**DELEGATED DECISION FOR APPLICATION FOR CERTIFICATE OF
LAWFUL DEVELOPMENT**

Reference no.: 2020/CL/92339/W

Site: 5, Rafborn Grove, Salendine Nook, Huddersfield,
HD3 3UB

Description: Certificate of lawfulness for proposed erection of
single storey extension to rear, demolition of existing conservatory and
external alterations

Job No.	G20072	Sheet No.	01	Revisions:	C
---------	--------	-----------	----	------------	---

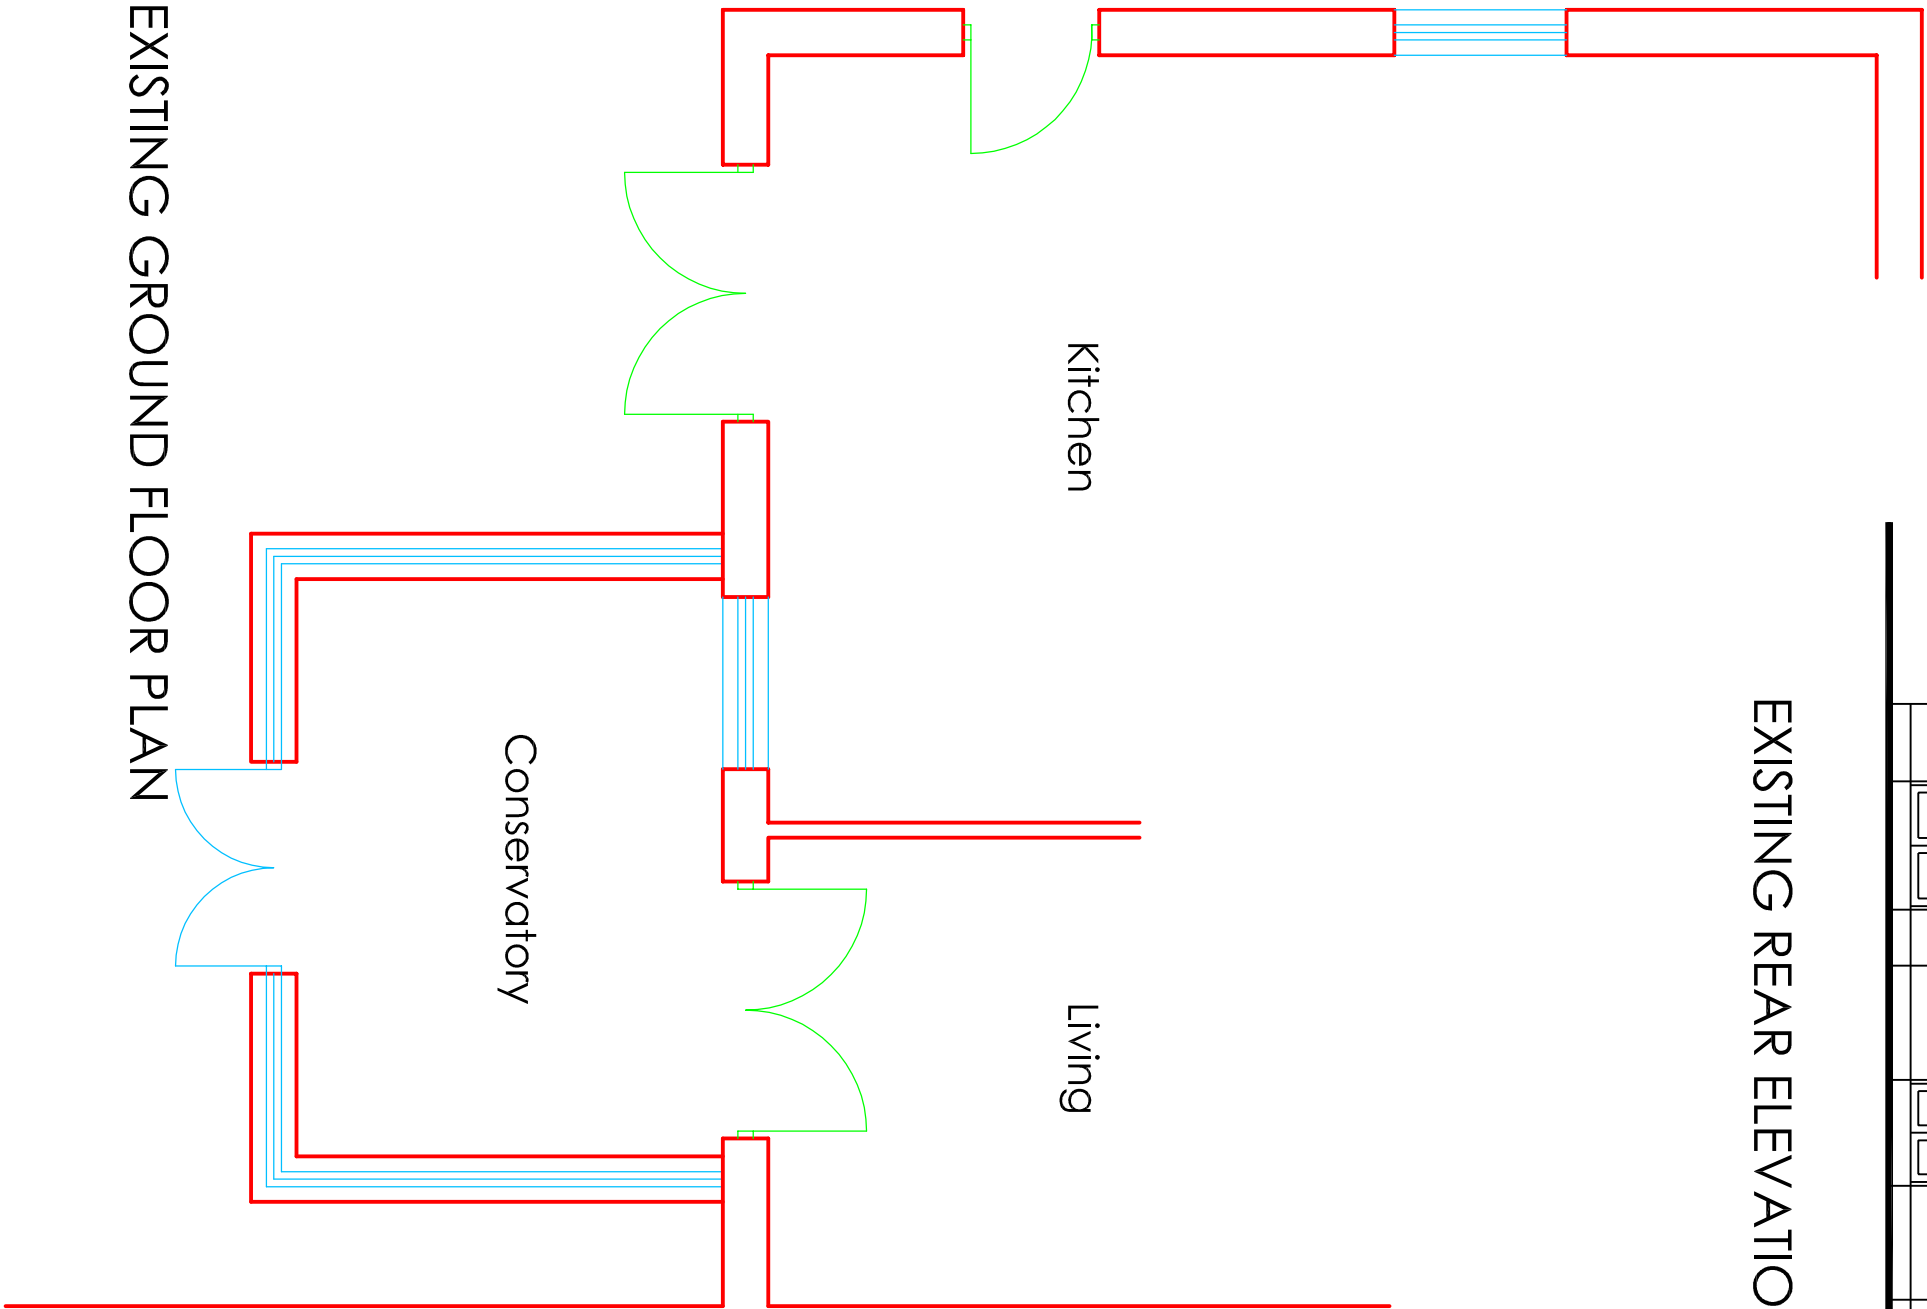
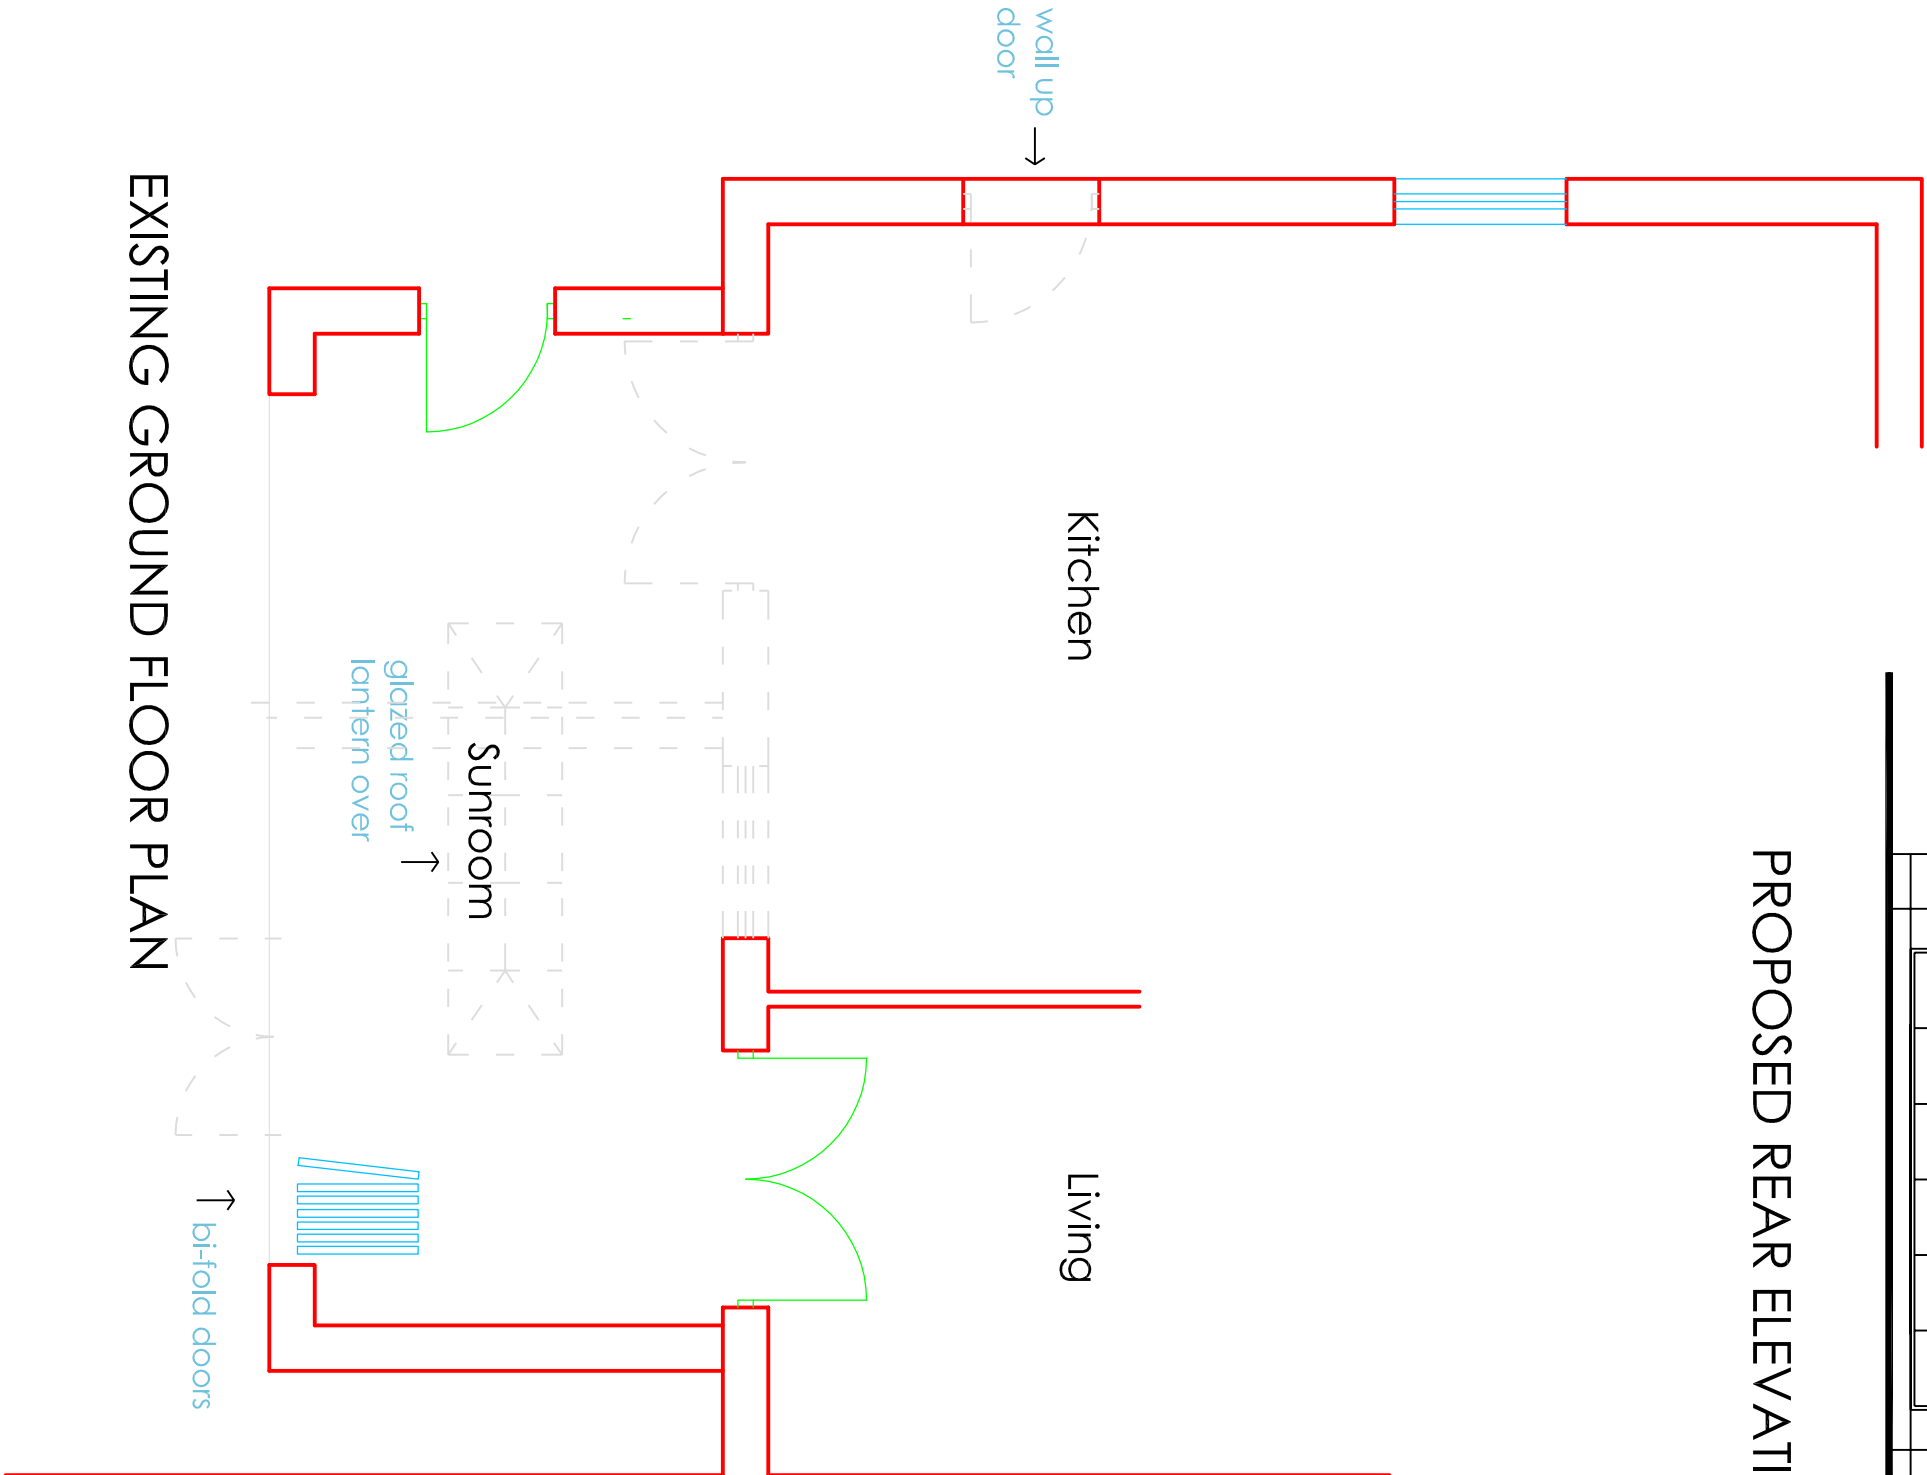
The case officer requested amended plans reducing the projection of the rear extension from 3.1m to 3m so the scheme would comply with Schedule, 2 Part 1, Class A.1(f) of the Town and Country Planning (General Permitted Development) (England) Order 2015(as amended). Amendments were received on 9th September 2020.

Comment: *The enlarged part of the dwelling would project 3m from the rear elevation of the original dwellinghouse and would not exceed 3.4m in height.*

Comment: *The eaves would not exceed 2.7m.*
